About the application

Application number: 2026/90452	
What is the application for?:	Erection of dwelling and associated works
Address of the site or building:	Land adj, Lower Common Lane, Scissett, Huddersfield, HD8 9HL
Postcode:

Proposed Site Plan 1:200

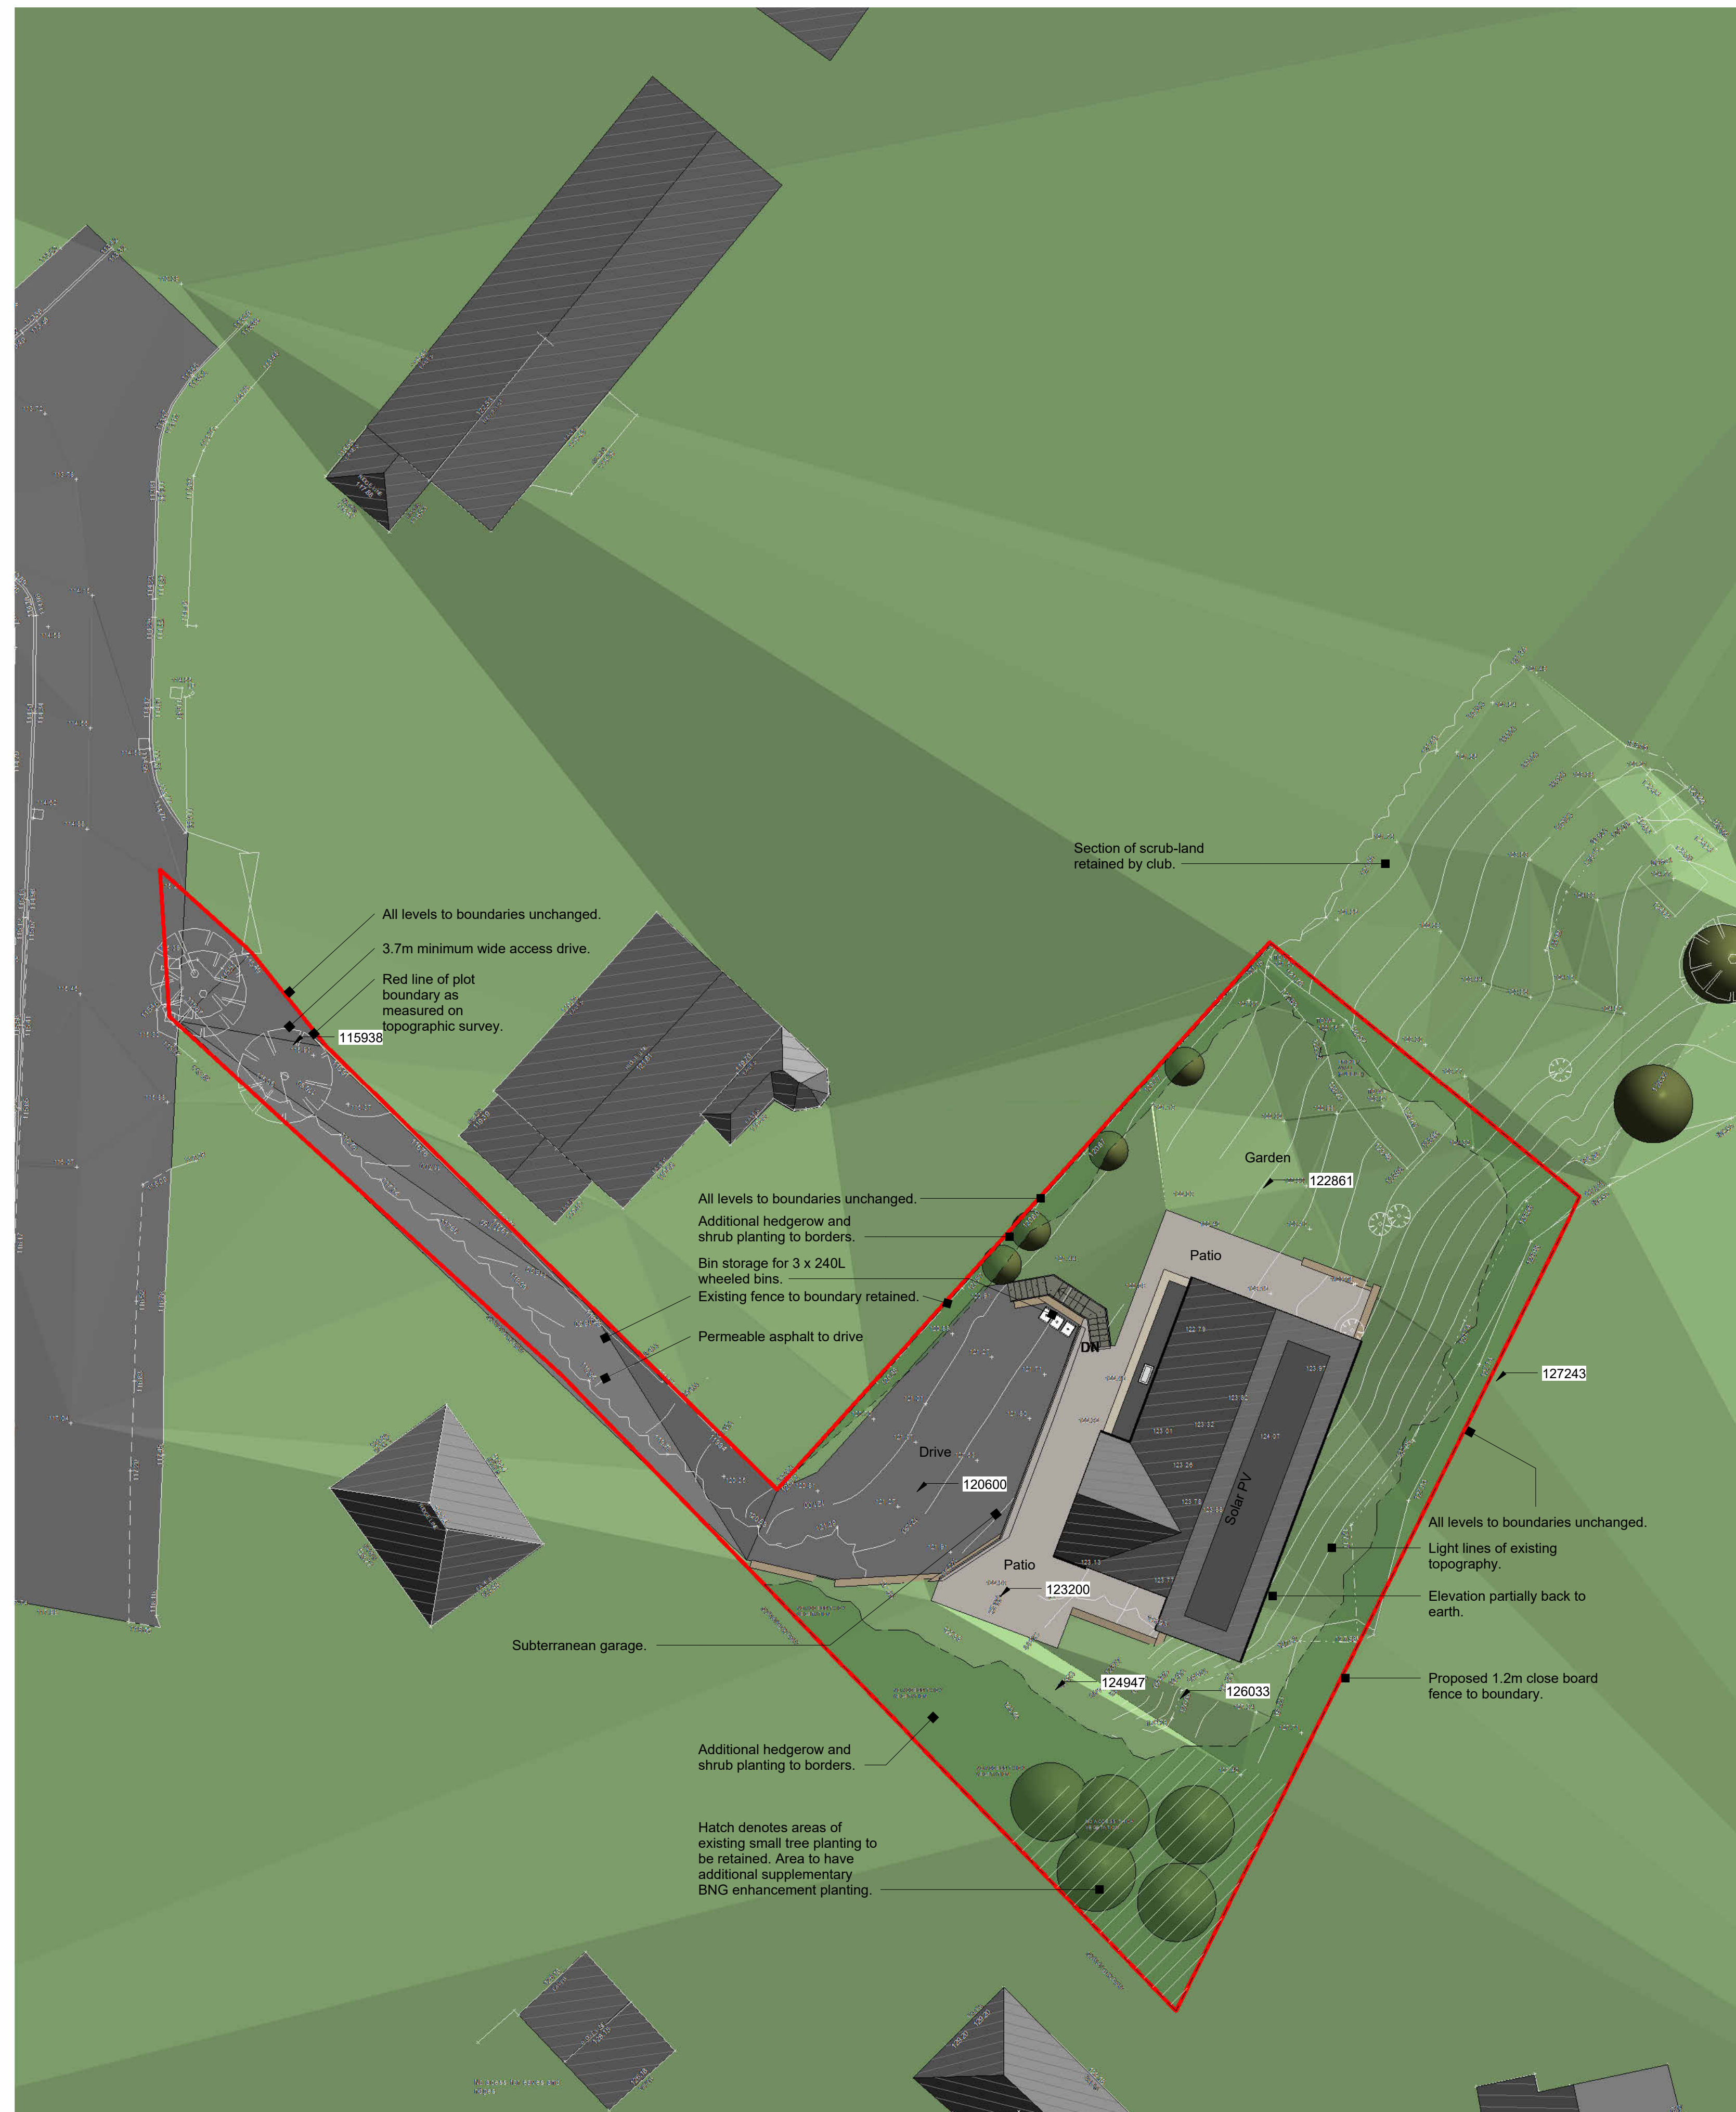
Type of comment: An objection	
Do you wish your comments to be published on the website anonymously?	<input checked="" type="checkbox"/> Yes
<p>Access. The plans say pedestrian and vehicle access how can that be achieved when the access is only 12feet wide.</p> <p>No 1 Lower Common Lane have a 12 foot right of way up the proposed access to maintain their boundary and fence. There must be a safety issue there.</p> <p>The access is 45 yards long with a gradient what would happen if one vehicle was entering at the same time as one exiting at only 12 feet in width there is not enough space for 2 vehicles to pass. Also is it wide enough for a fire engine to access the property and turn round ?</p> <p>Within the first 30 yards of a busy junction with Barnsley Road there would be 5 driveways one of which is into a day nursery car park there are KEEP CLEAR and WHITE LINES on the road but parents still park there instead of using the car park and staff park cars on the roadside making it narrow and not safe for children and pedestrians another driveway would only make matters worse.</p> <p>AN ACCIDENT WAITING TO HAPPEN</p> <p>I would request a visit from planning and highways before a decision is made .</p> <p>The house itself is 3 stories so not in keeping with other properties. On the first floor there is a rap around patio and on the second floor a veranda which looks straight down onto the rear and garden of the bungalow below meaning that there privacy is taken away.</p> <p>They are my objections</p>
